**From:** Coote, David <David.Coote@safework.nsw.gov.au>  
**Sent:** Tuesday, 6 September 2016 5:58 PM  
**To:** Bianca Thornton  
**Cc:** Fernando, Sohan  
**Subject:** Botany Industrial Park Subdivision (DA 30/98 MOD 3) - Notification

Comments as requested from SWNSW:

Figure 5: Proposed Modification with Changes Indicated in Red (DA 30/98 MOD3)

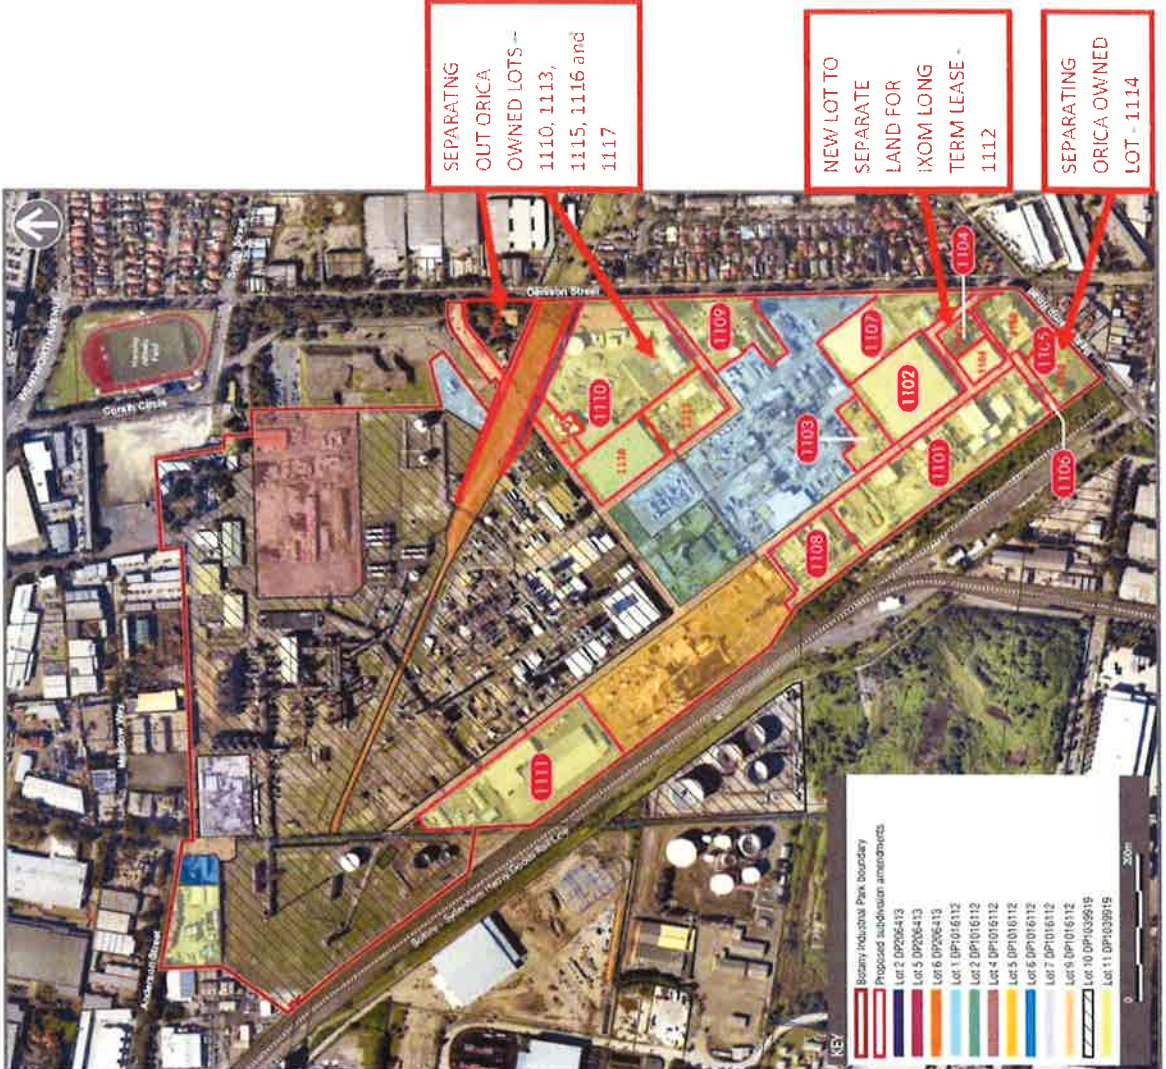
1. The plan attached to the Orica letter dated 4/8/16 shows that Orica intends to separate out some lots. In this case, any new occupant(s) of the separated out lots may potentially be much closer to the CAP, GTP and HCB, than any third parties previously have. The risks posed by activities of any new occupant to current BIP operations (and vice versa) will potentially be higher than that between the current sites within the BIP.  
This would potentially include the security risks of addition occupants.  
The current BIP arrangement appears to be that the risks posed from one operator to another within the BIP do not have to comply with the HIPAP 4 individual fatality risk criteria at boundary of industrial site of 50E-6.  
It is suggested that planning give consideration as to how these risks are to be addressed and how a potential new occupant will be made aware of the risks posed by activities within the BIP.
